Your ref:
Our ref: 23/02116/F
Please ask for: Mrs Lesley Raby
Direct dial: 01553 616818
E-mail: borough.planning@west-norfolk.gov.uk

TOWN AND COUNTRY PLANNING ACT 1990

Details: **Proposed pitched roof and rear patio at Cockles 6A South Beach Heacham King's Lynn Norfolk**

Proposed Ground Floor Plan 1:50 @ A1

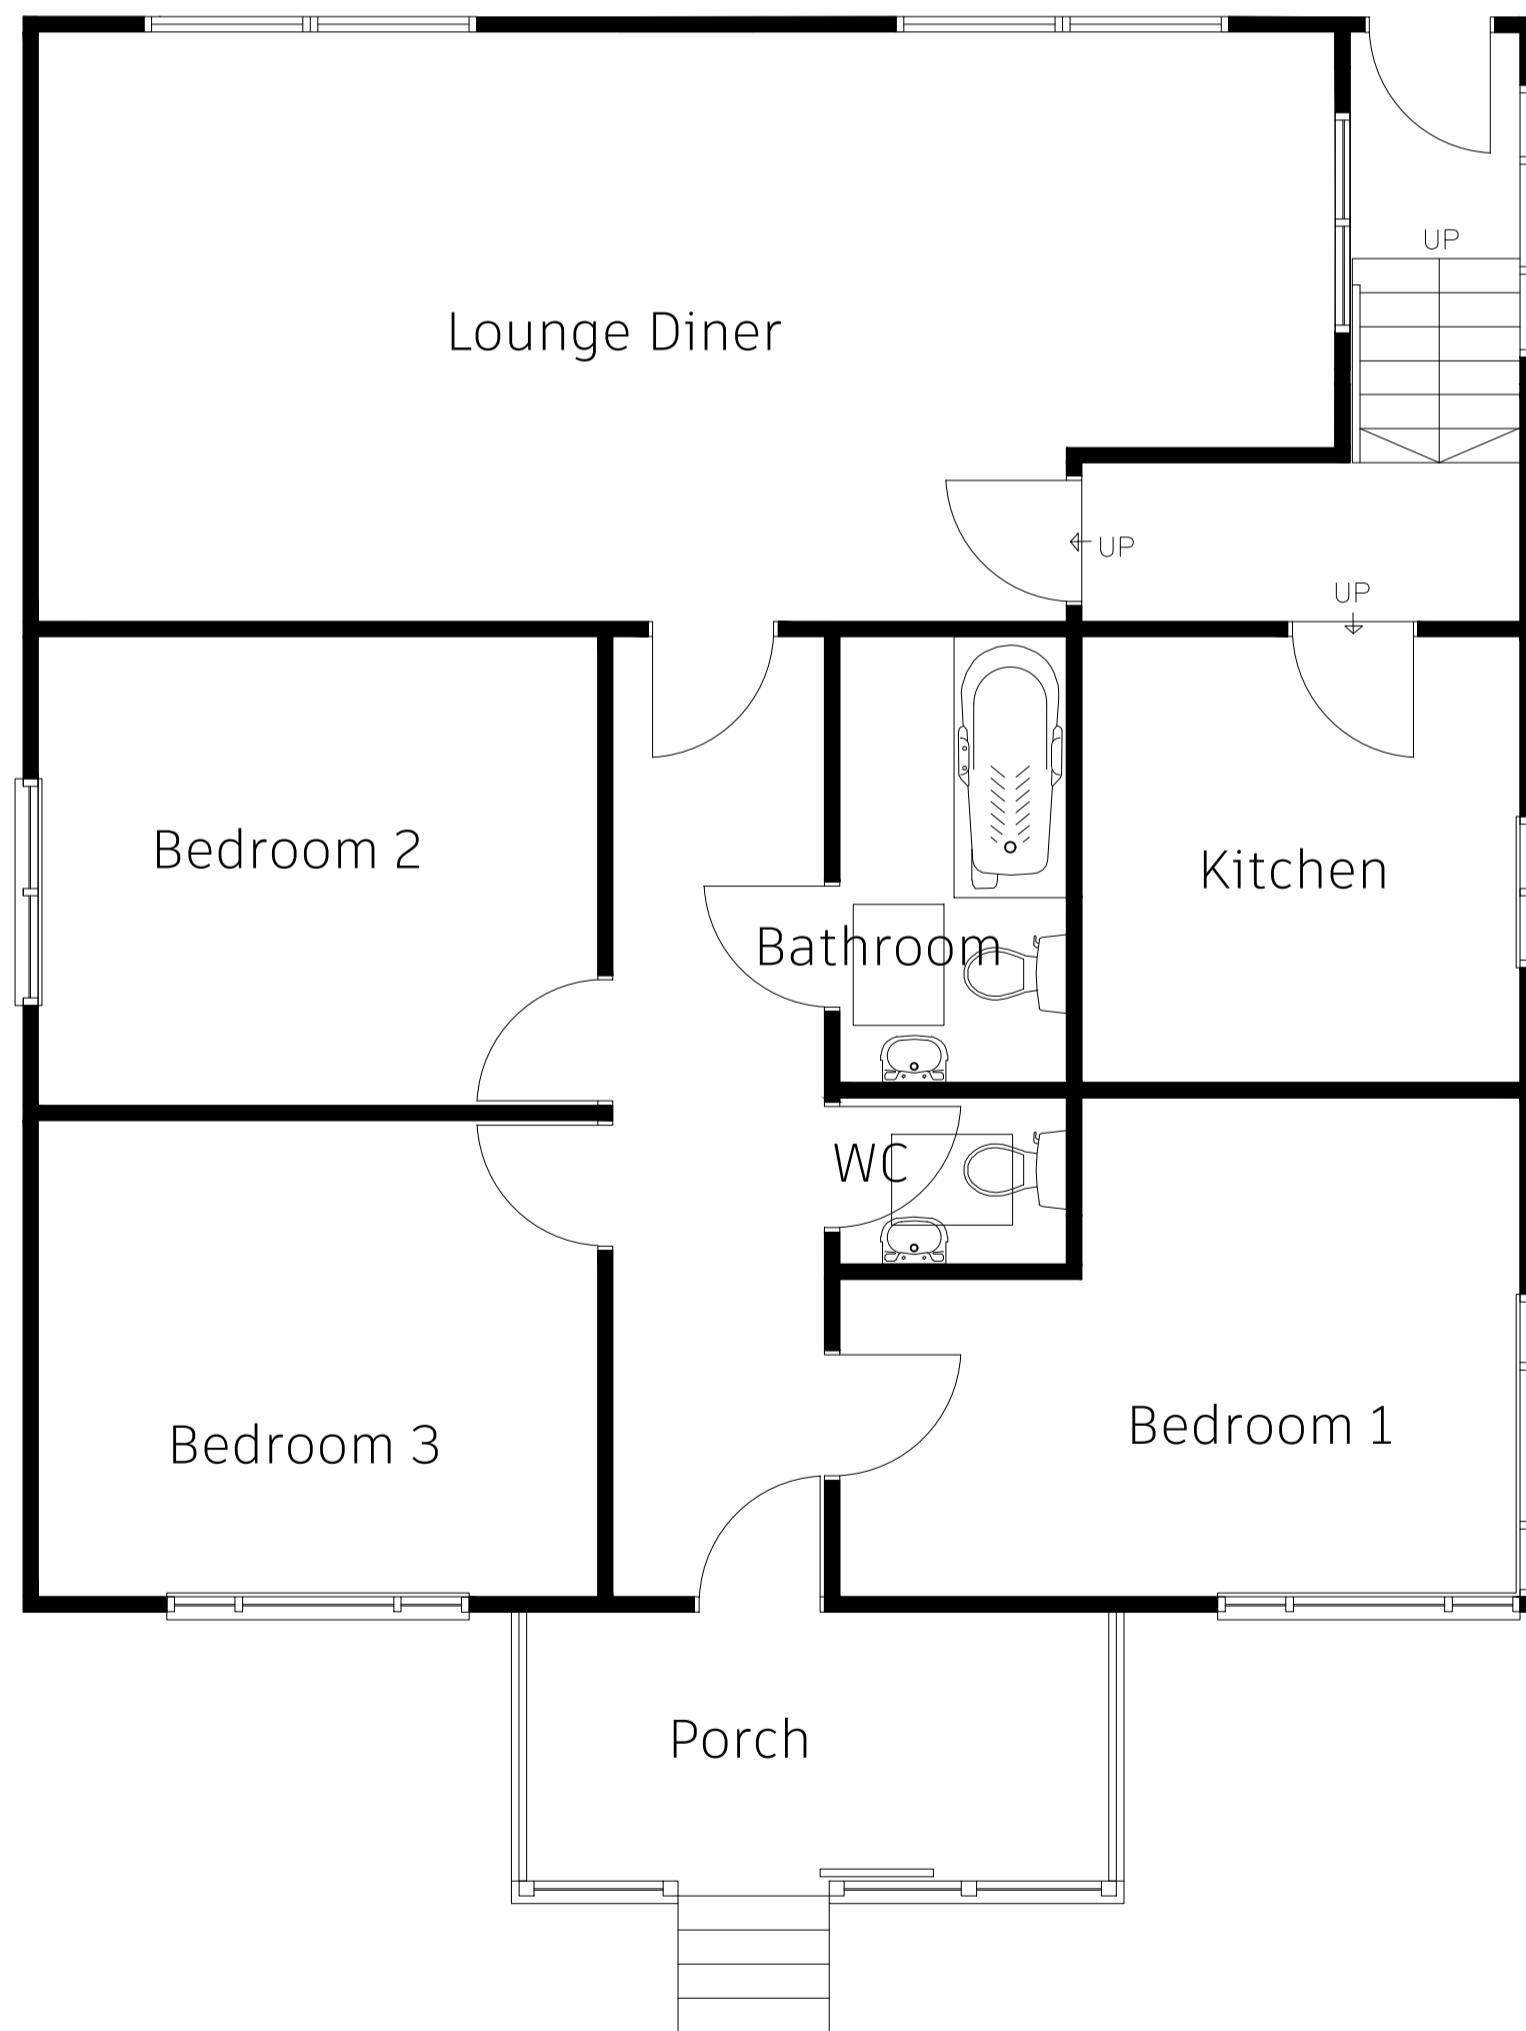
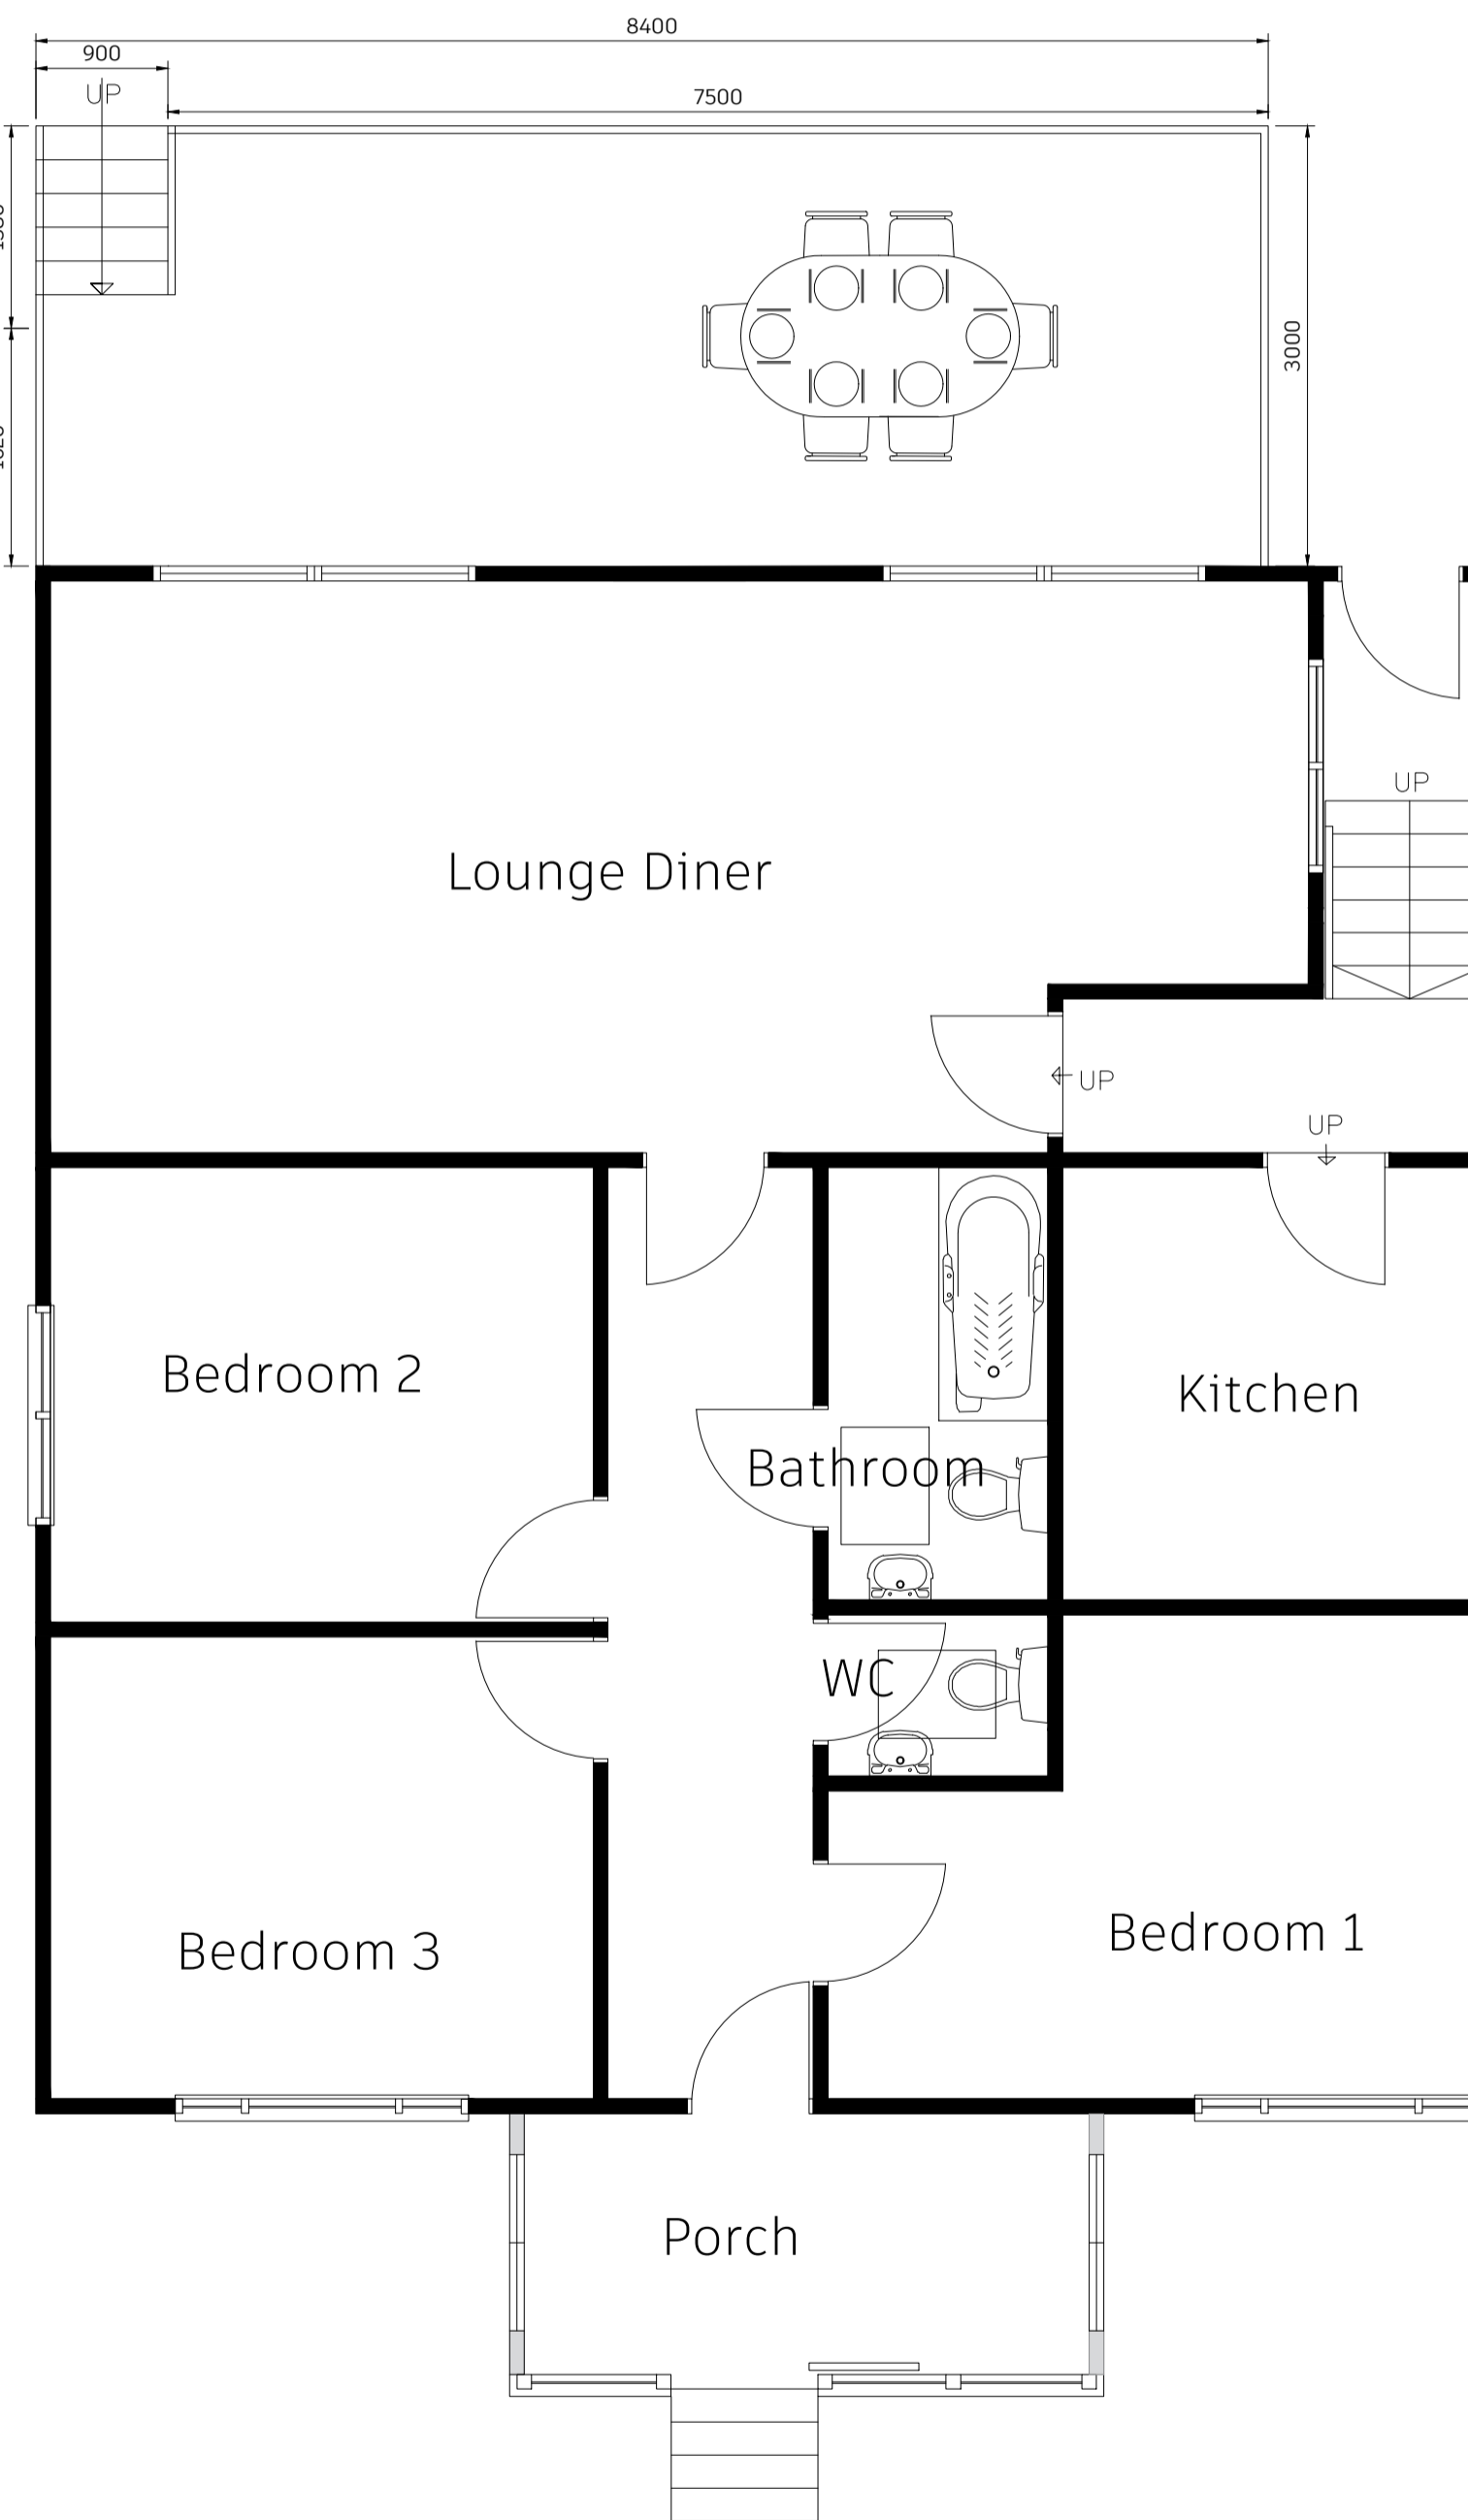
1. As the property lies within an area at risk to flooding, please complete the simplified Matrix and return it. The Matrix can be found at https://www.west-norfolk.gov.uk/info/20173/information_for_planning_agents/231/flood_risk_information
2. Confirm that the floor levels will match the existing.
Confirm that the site levels will remain the same.
3. Provide the existing roof plan.
